Our Ref: **EP/70/12/**
Your Ref:

Application for Planning Permission for Works or Extension to a Dwelling

Development Alterations & first floor extension, providing a reduced garden room on the ground floor, together with conversion of garage to a gym & 2 new bedrooms, study & bathroom to first floor. Removal of existing pitched roof & replace with lower mono pitched roof

Location Sandgate House South Strand East Preston Littlehampton

1207 SK23
Sandgate House, East Preston
First Floor As Proposed
June 2012
scale: 1:100

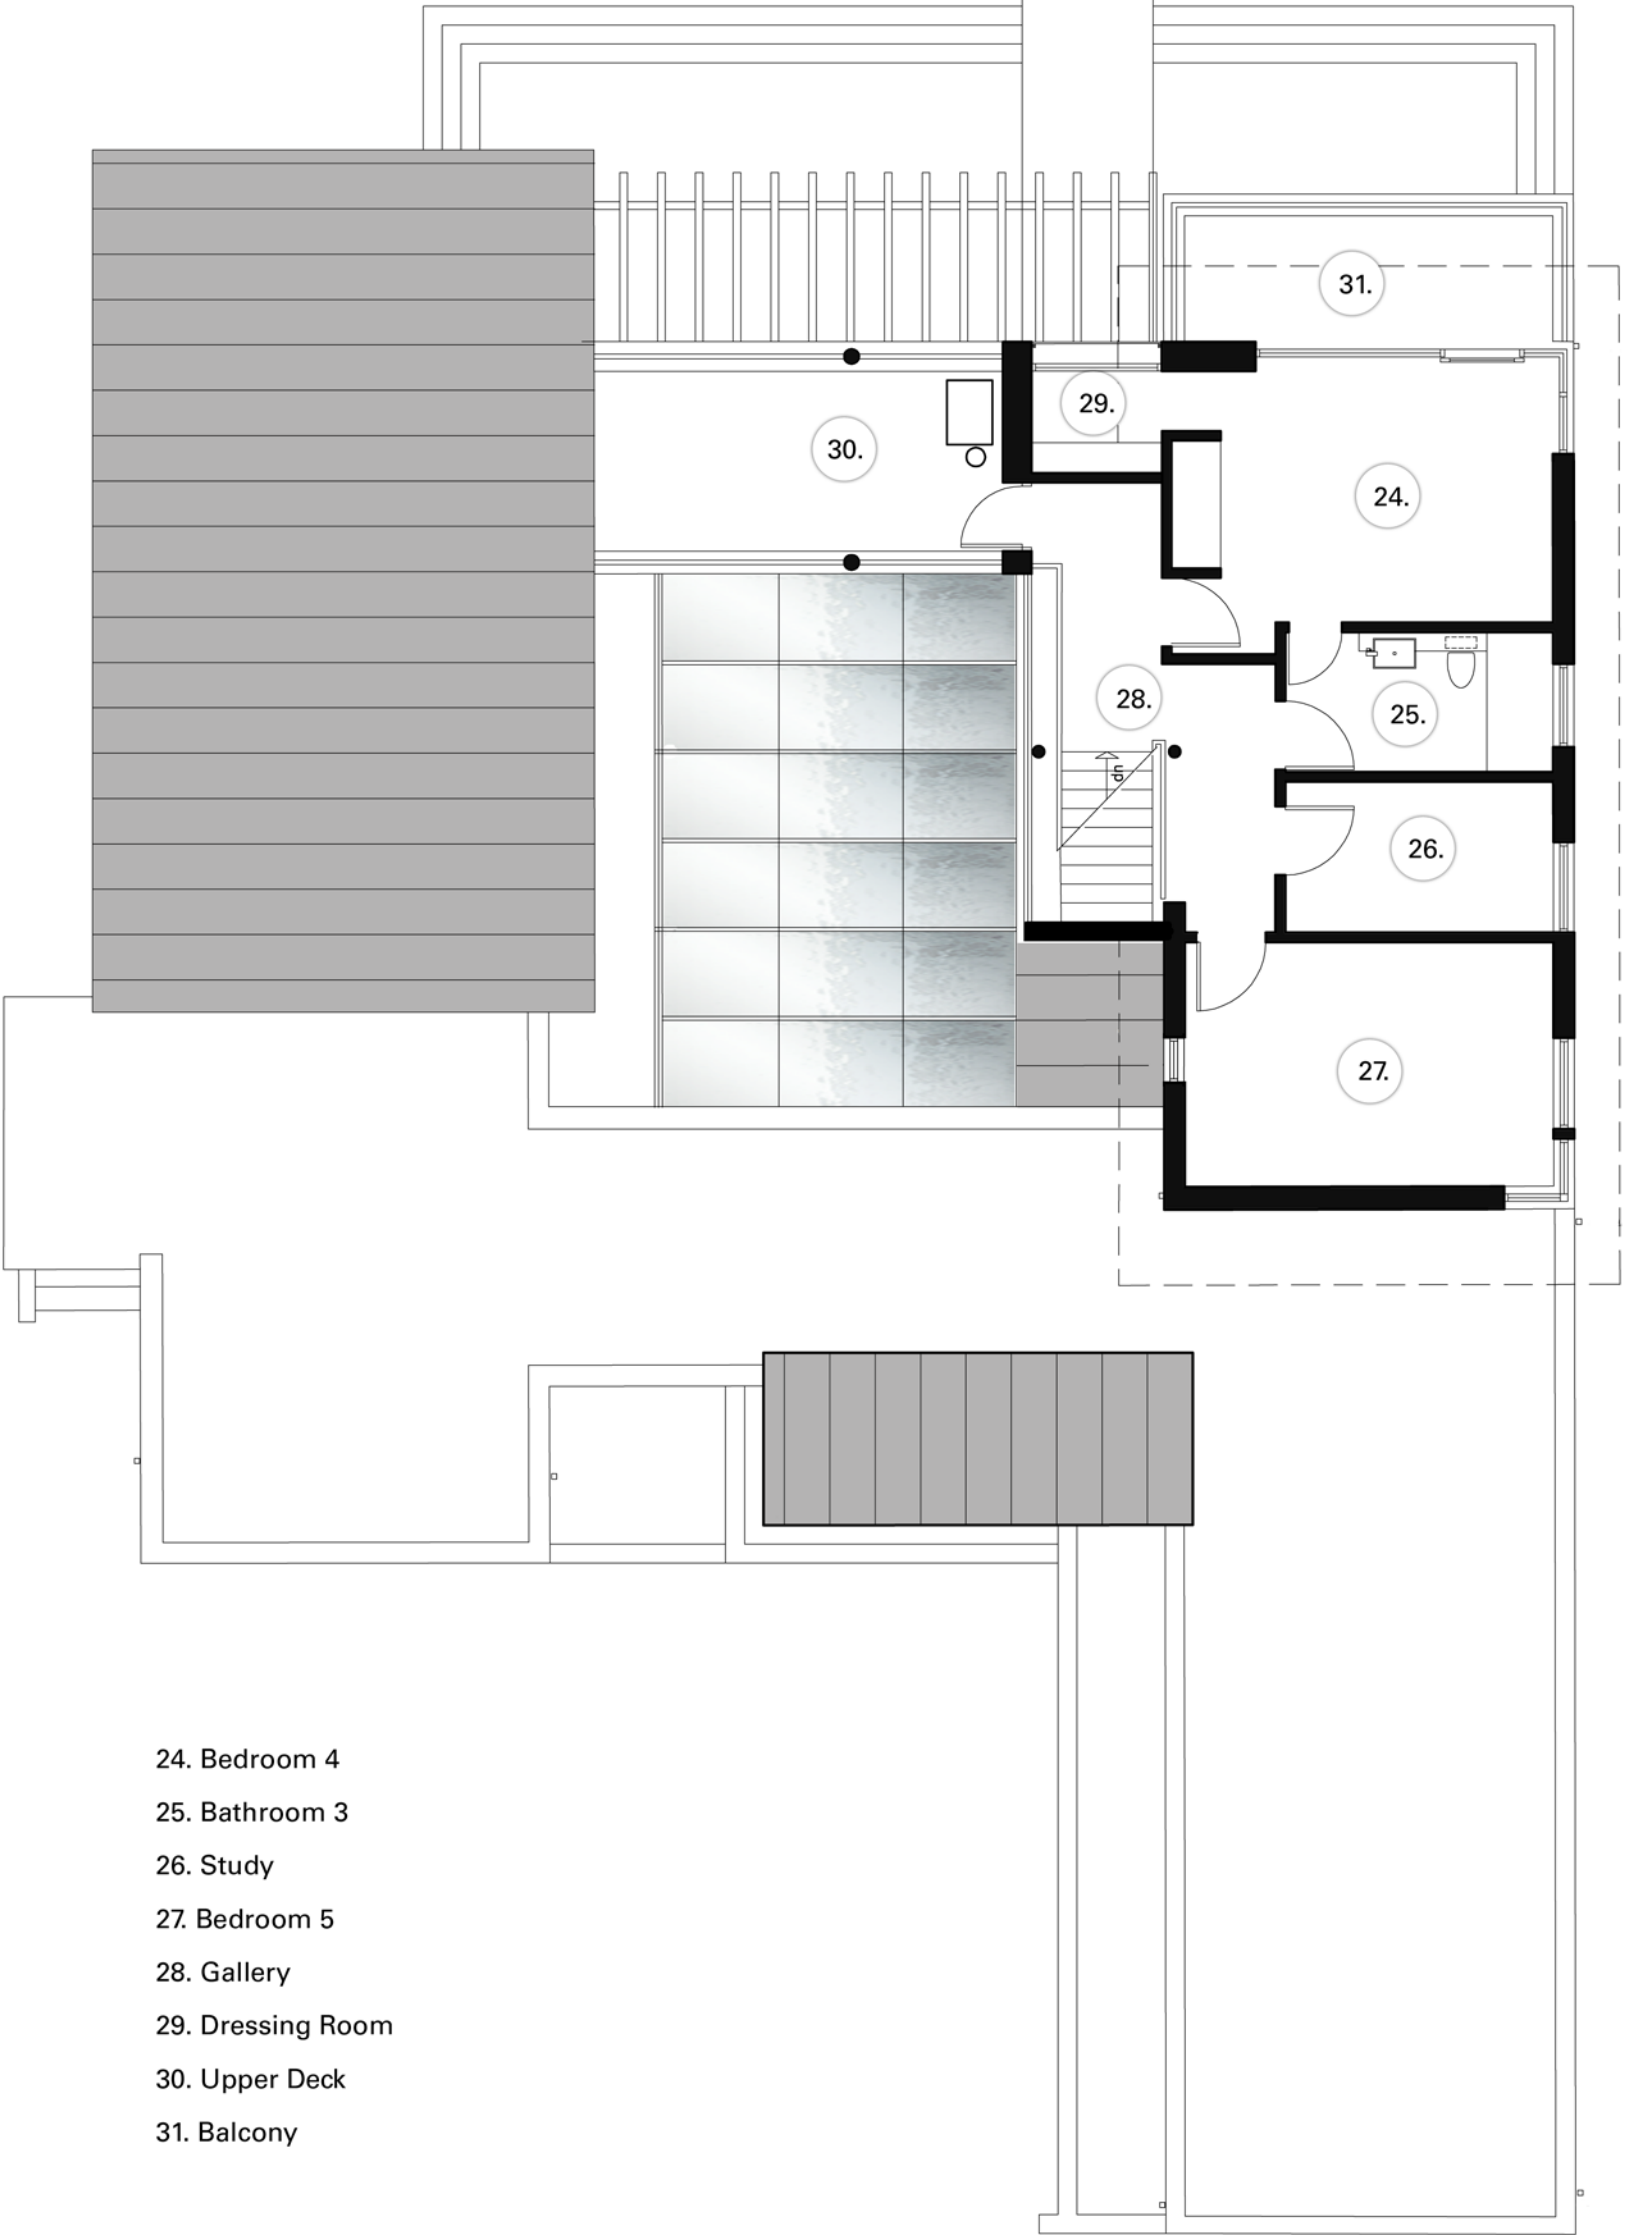
X There appears to be a window shown on the proposed south elevation (04) which is not shown on the proposed first floor plan. Please provide 1 electronic or 3 paper copies of a revised proposed first floor plan if this is the case.

West Elevation

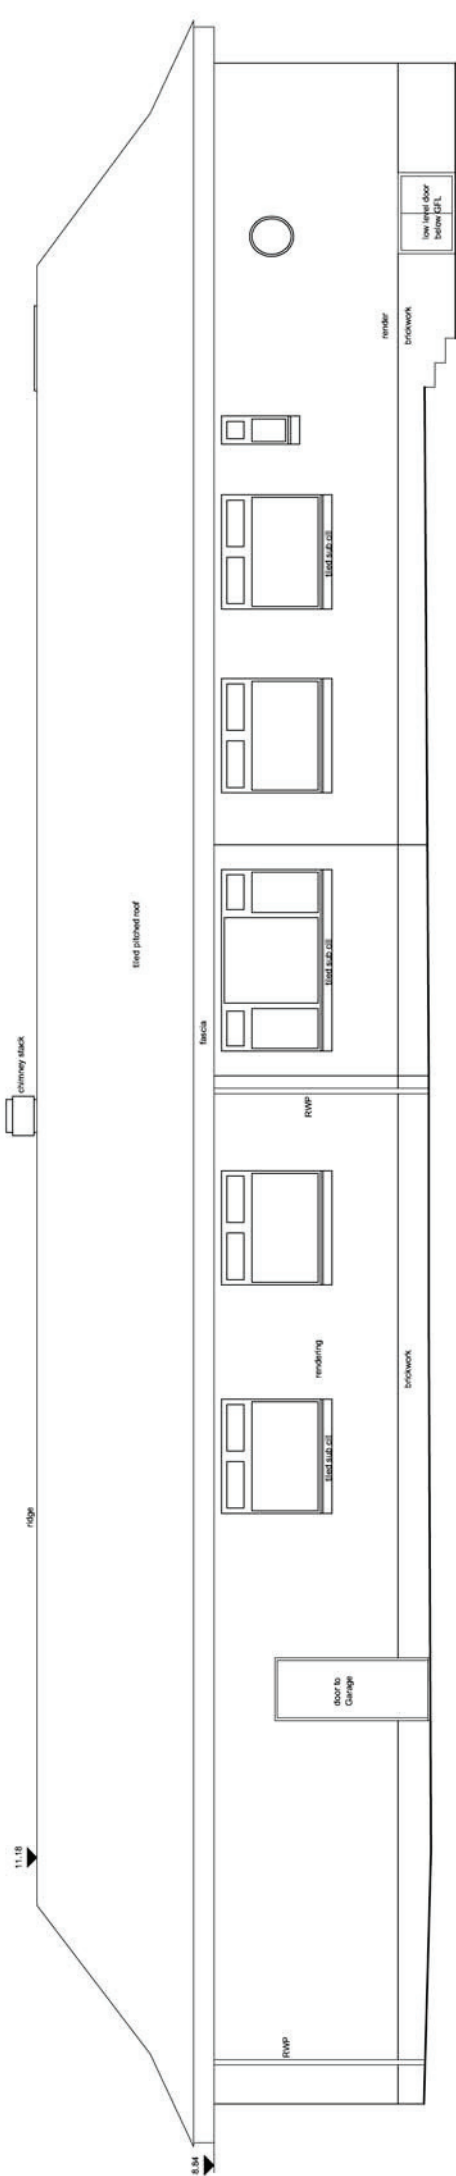
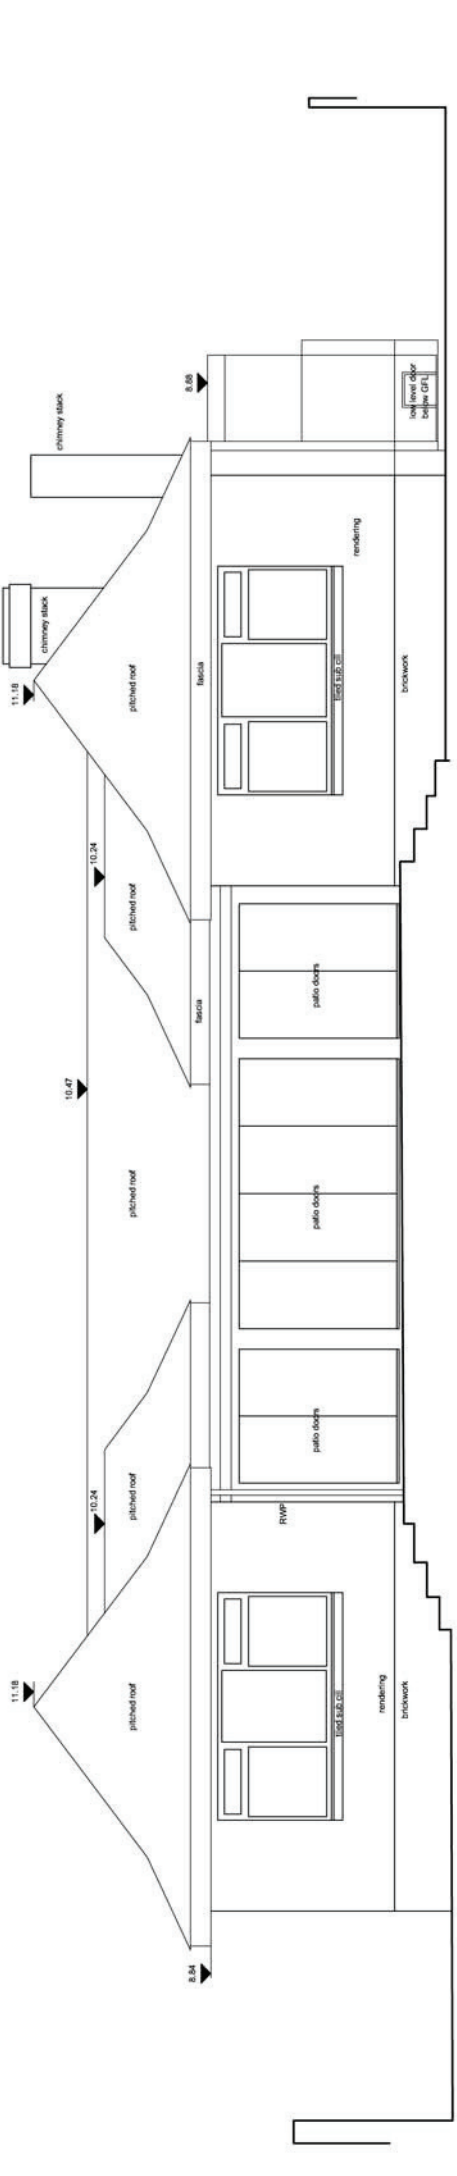
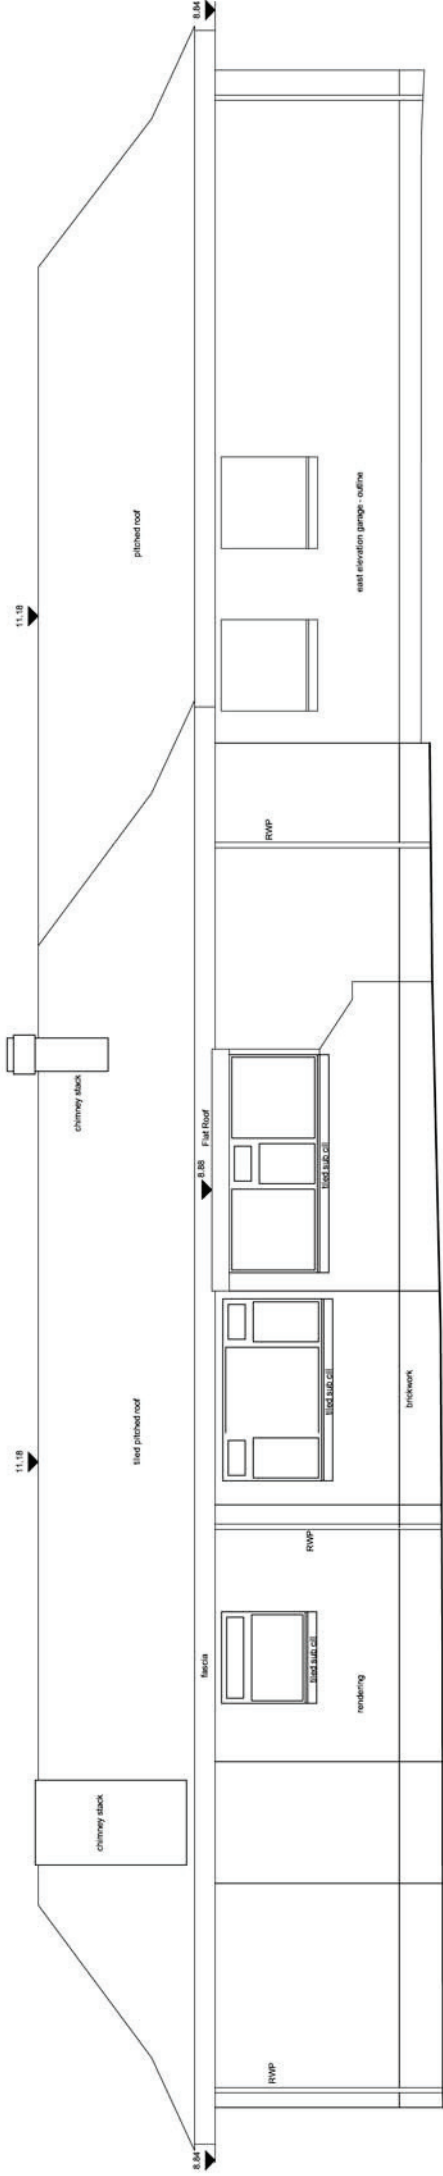
Please provide 1 electronic or 3 paper copies of revised existing east and west elevations. They appear to be labelled incorrectly (the east elevation is marked as west and vice versa). Please amend.
